re: **Geotechnical Response to City Comments**
 Proposed Residential Development
 Trailsedge Blocks 193 & 194 - Ottawa

file: PG5397-MEMO.02

Paterson Group (Paterson) prepared the following memo to provide our responses to the geotechnical-related comments issued on March 9, 2021 by Ms. Sara Mashaie at the City of Ottawa. These responses should be read in conjunction with the Geotechnical Investigation Report (Paterson Group Report PG5397-1 Revision 1 dated December 9, 2020) which has been prepared for this site.

LANDSCAPE PLAN

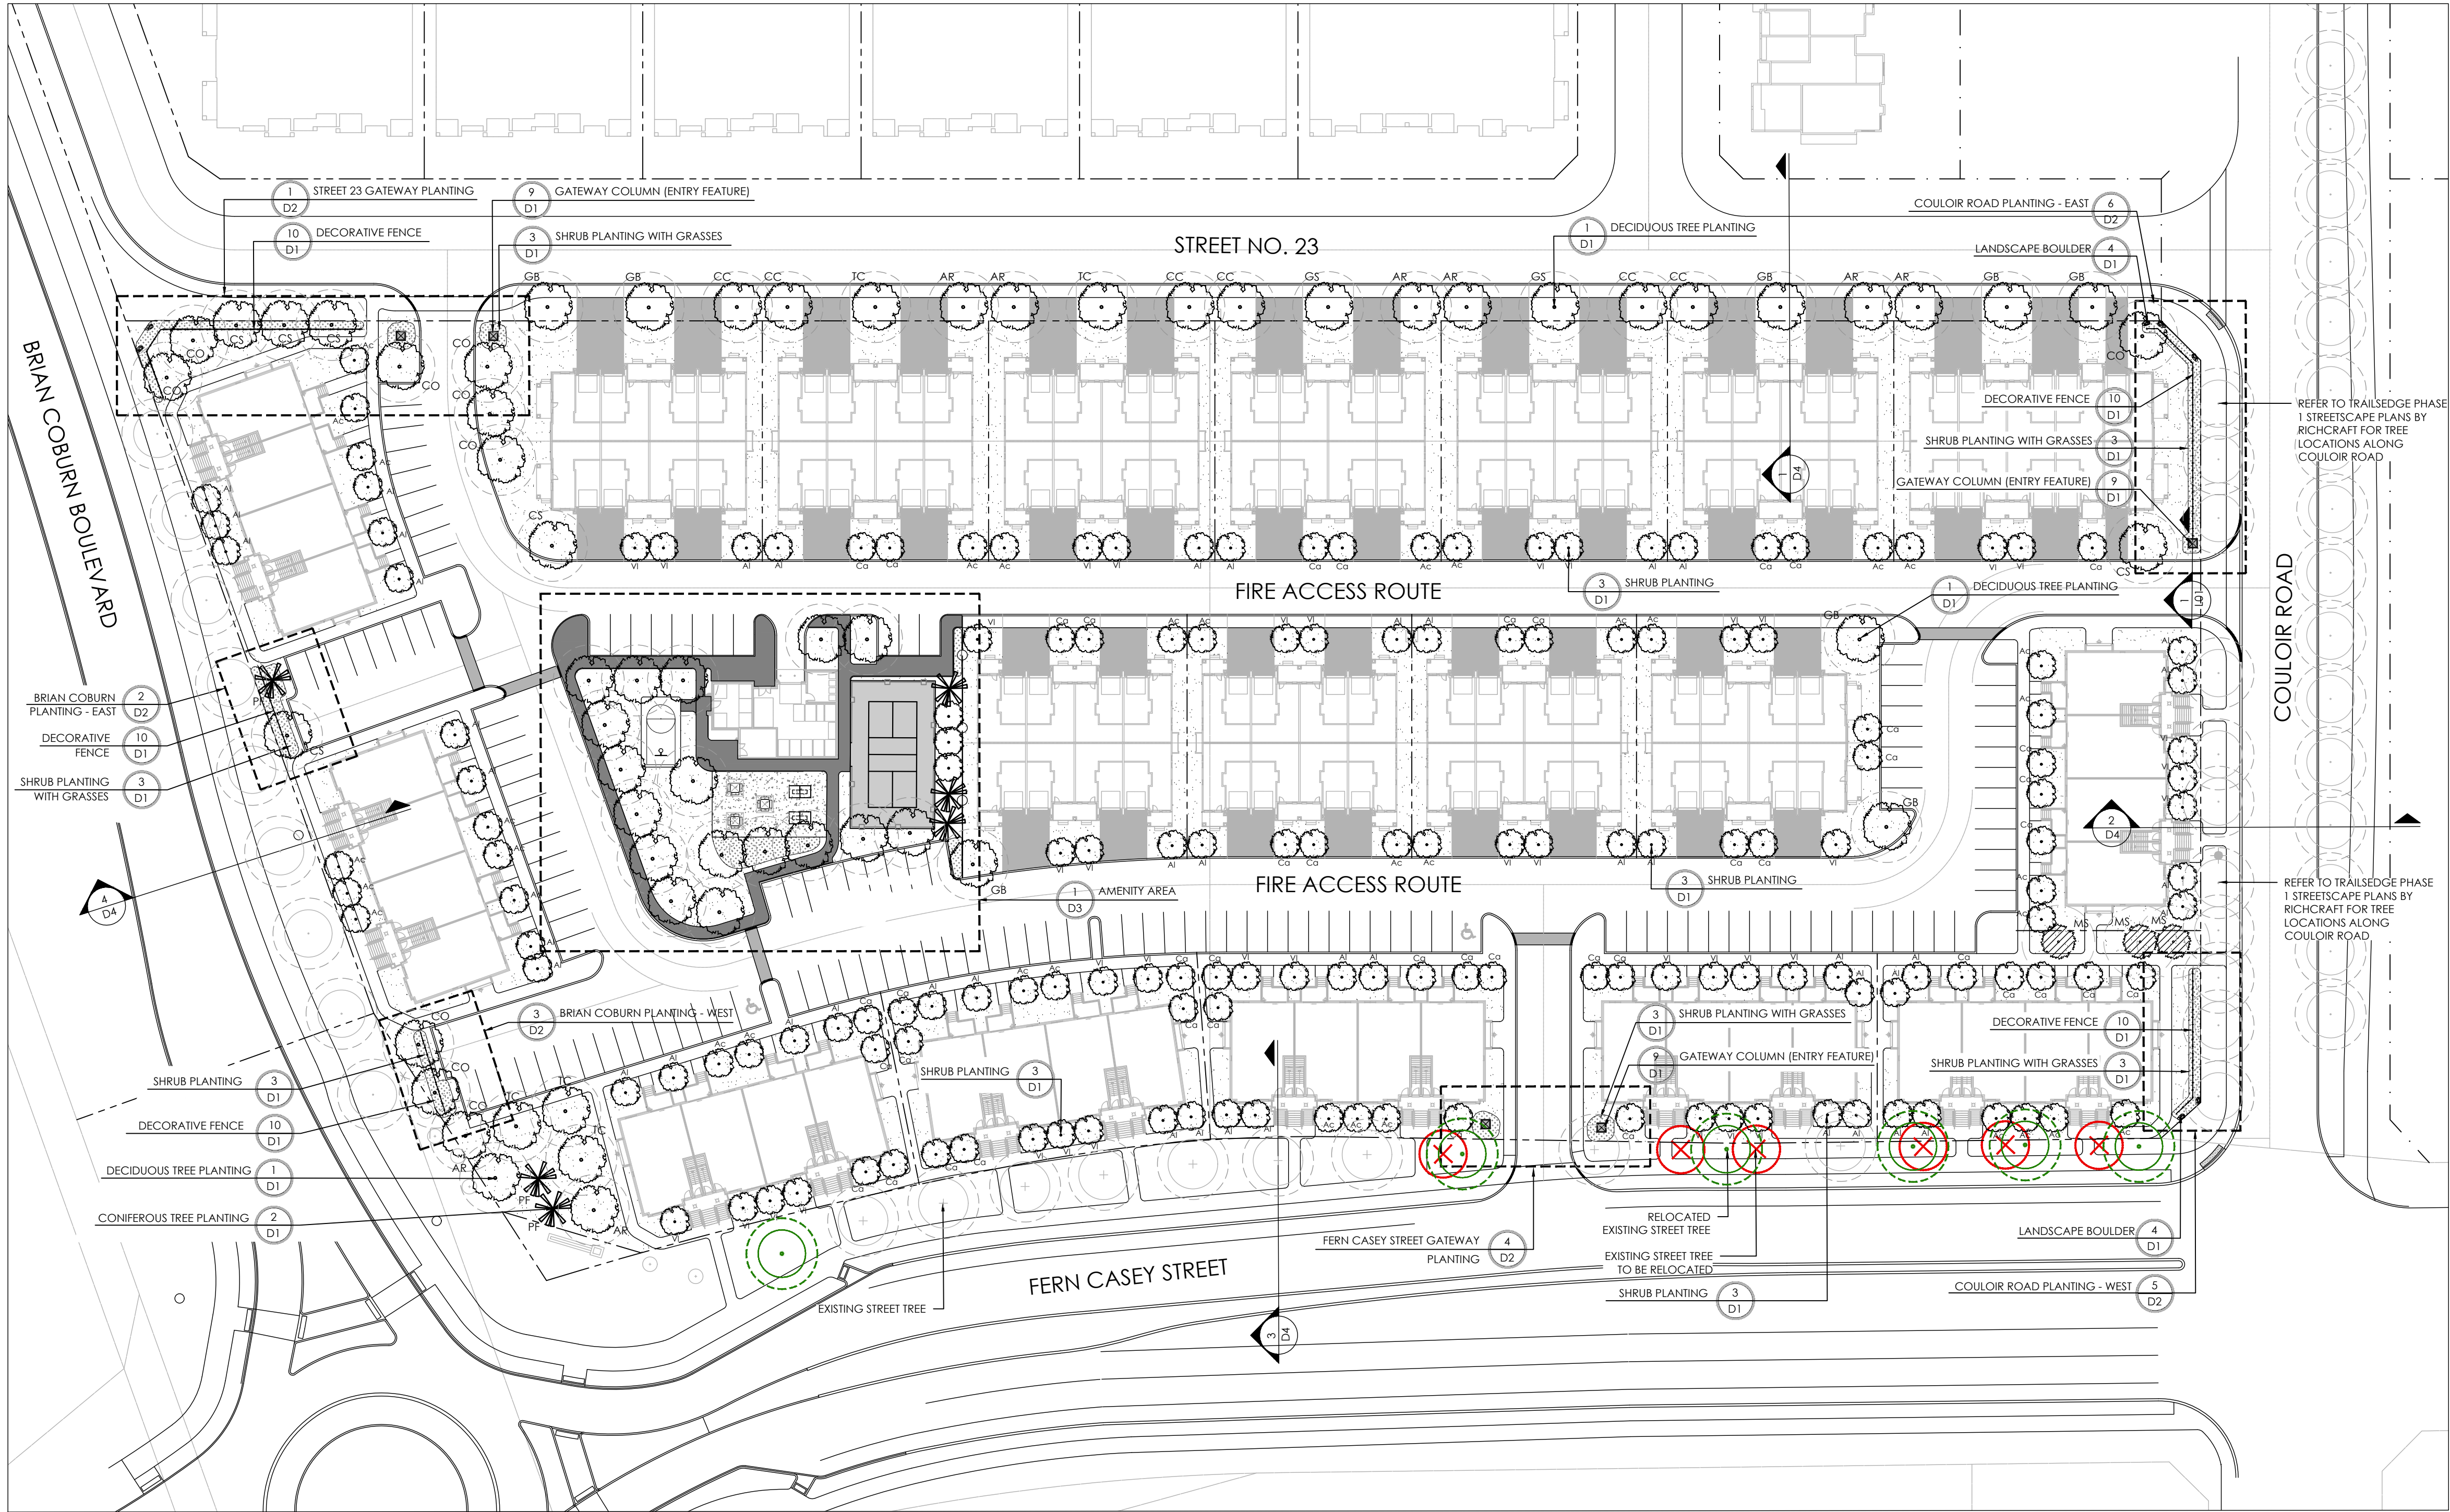
Comment: *Ensure that the latest revised landscape plan is reviewed in conjunction with tree planting restrictions and recommendations contain in the report.*

Response: The current Landscape Plan (Drawing L01 Revision 5 dated April 23, 2021 and prepared by Nak Design Strategies) was reviewed for consistency with the recommended tree planting setbacks provided in the Geotechnical Investigation Report (Paterson Group Report PG5397-1 Revision 1 dated December 9, 2020). Per this report and the City of Ottawa Tree Planting in Sensitive Marine Clay Soils (2017 Guidelines), a reduced tree planting setback of 4.5 m is applicable for small trees (less than 7.5 m mature height) and medium trees (mature height of 7.5 to 14 m) at this site.

Based on our review, small and medium trees on the Landscape Plan have been provided with a setback of 4.5 m or greater from the foundation walls of the proposed buildings.

There are shrubs located within the 4.5 m setback in certain areas, and these are considered acceptable provided the roots do not extend more than 1 m below finished grades.
